Re: SEPA SE-23-00016, LP-23-00003 TRS: T22, R11E, Section 9, Louise McAllister Trust

SUBJECT: WDFW COMMENTS ON LP-23-00003 McAllister Summit

In future correspondence please refer to:
Project Tracking Code: 2023-08-05233
Property: Kittitas County_McAllister Summit Subdivision (LP-23-00003)
Re: Survey Requested

TO: All Staff
FROM: Public Works Plan Review Team
DATE: August 25, 2023
SUBJECT: LP-23-00003 McAllister Summit

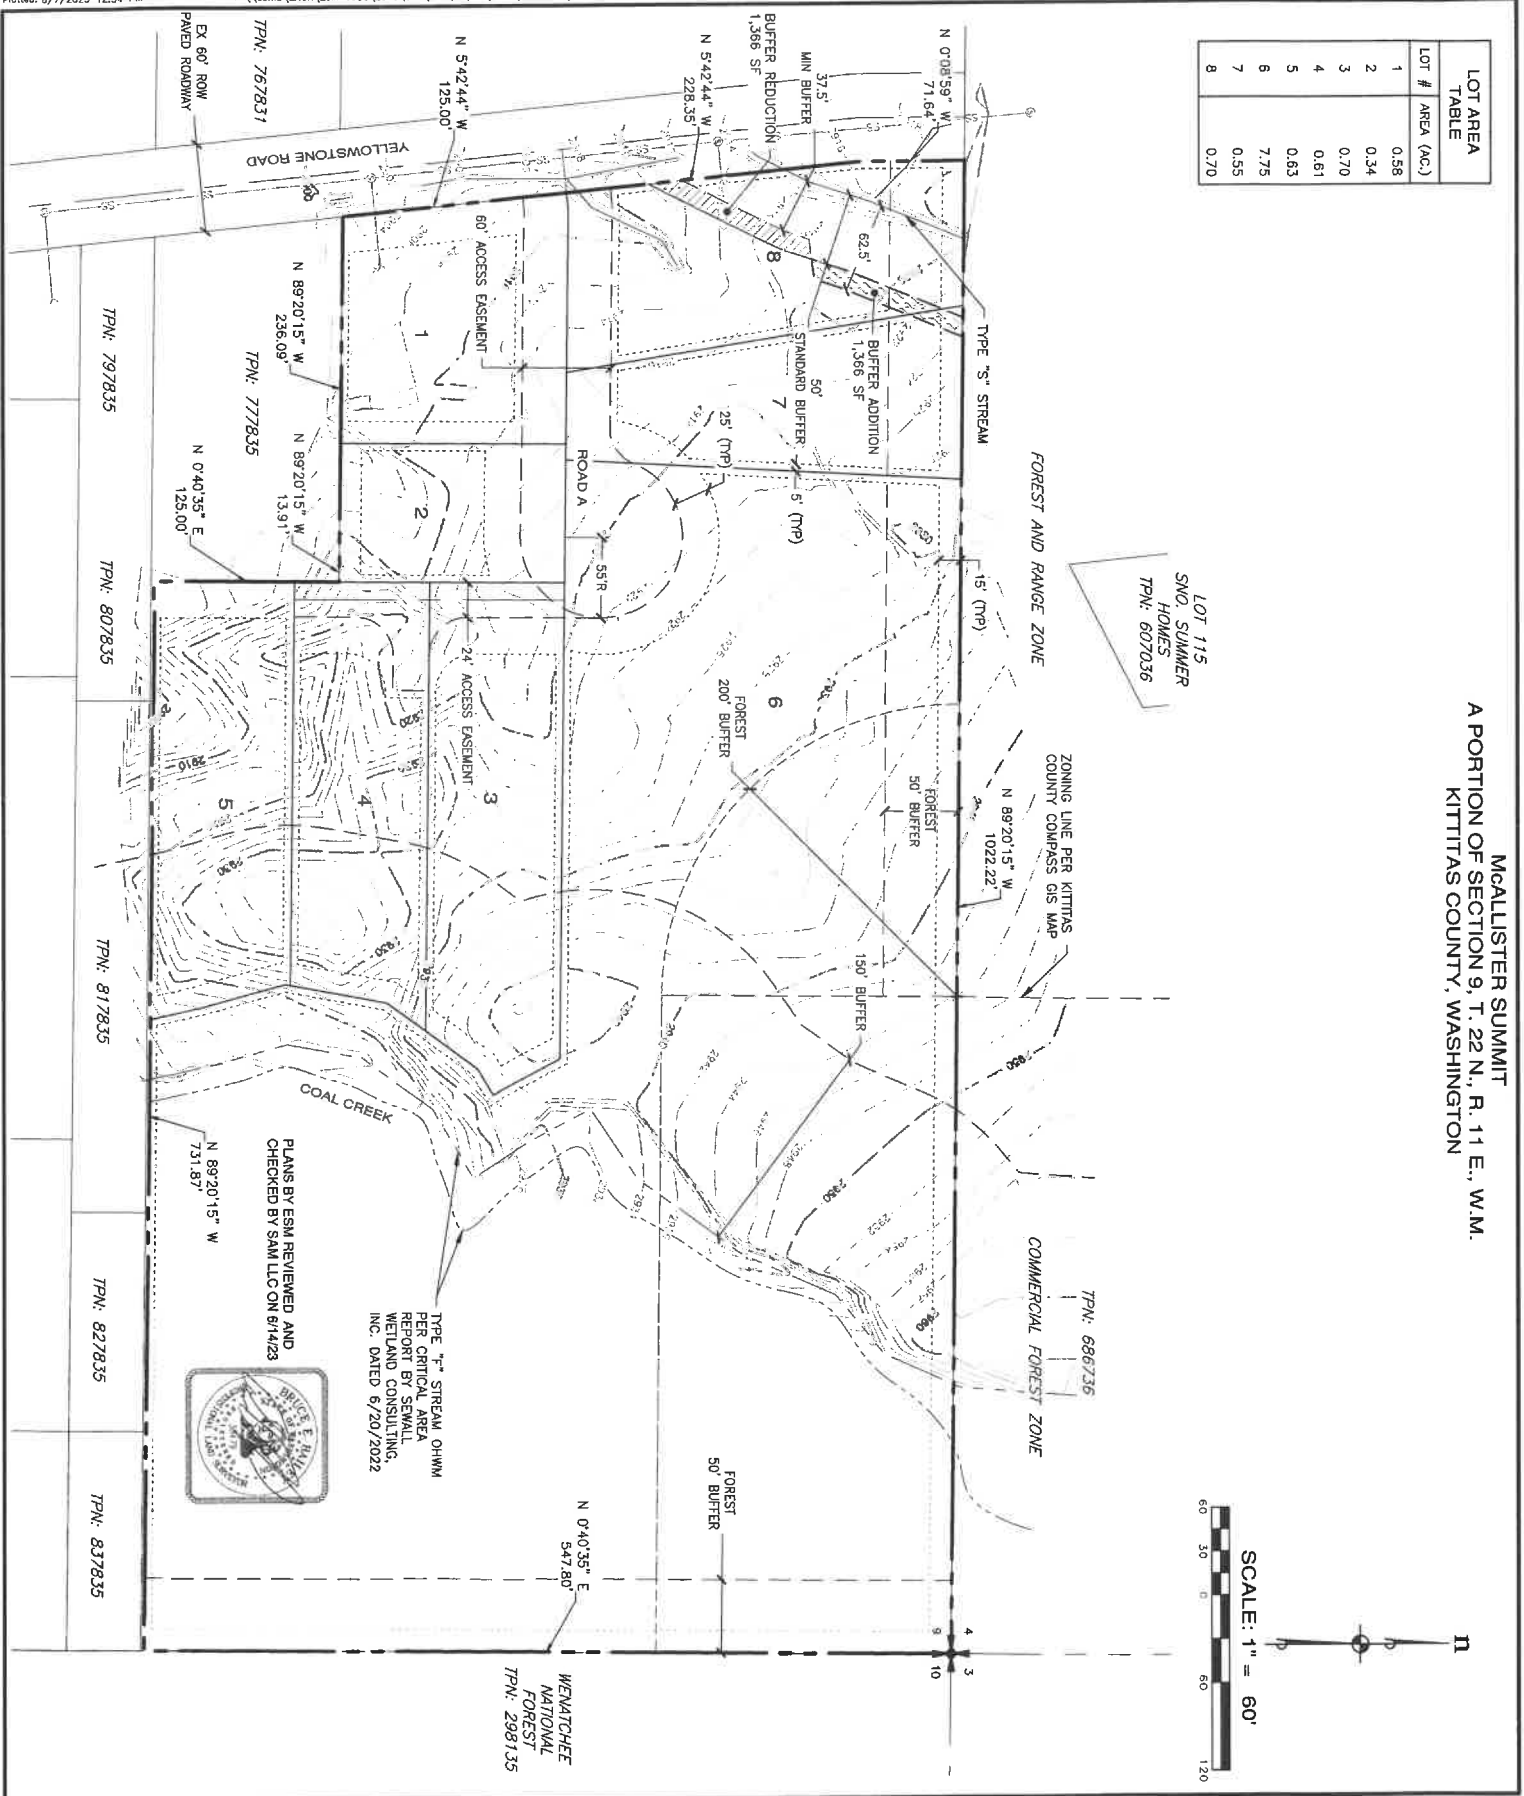
While we appreciate that the critical areas report has outlined Coal Creek correctly as a fish-bearing stream and applied appropriate setbacks, the description of the other mapped Type F stream, in the NW corner, as seasonally dry does not necessarily preclude it being habitat to fish. The stream is shown on the map as being connected to the same stream where nearby WDFW did assess the stream to be fish bearing earlier in 2023. Before the plat is approved, WDFW requests the ability to review the stream with the applicant or their consultant and review and discuss the stream typing of this stream.

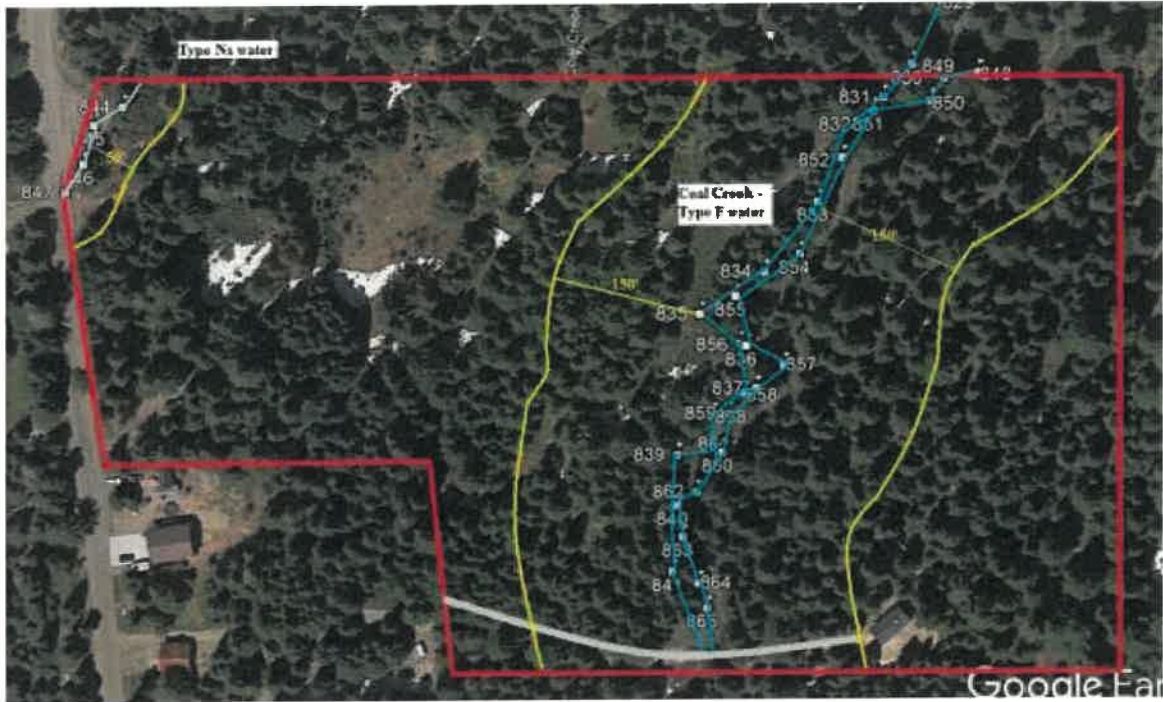
As a note, we are concerned that the writer of the critical area report provided claims that a creek with a county maintained culvert was dry because a neighbor informed him that “no water has been seen in the feature for approximately 10 years since the last big flooding event sent water down Yellowstone Road”. As someone who lives adjacent to this creek year-round, I do not believe this to be true. This channel carries snowmelt and runoff downstream to a fish-bearing creek. Also, Yellowstone Road does consistently have minor flooding during storm events with several inches to a foot of running water headed downslope. With large amounts of snow melt and the extreme weather events characteristic of the area I’m concerned that a visit to this site during the dry season, informed by one unnamed neighbor, does not give the County an adequate understanding of the property. The fact that the Kittitas County would issue a DNS based on a Critical Area Report that uses an individual neighbor’s recollection as a source seems deficient.
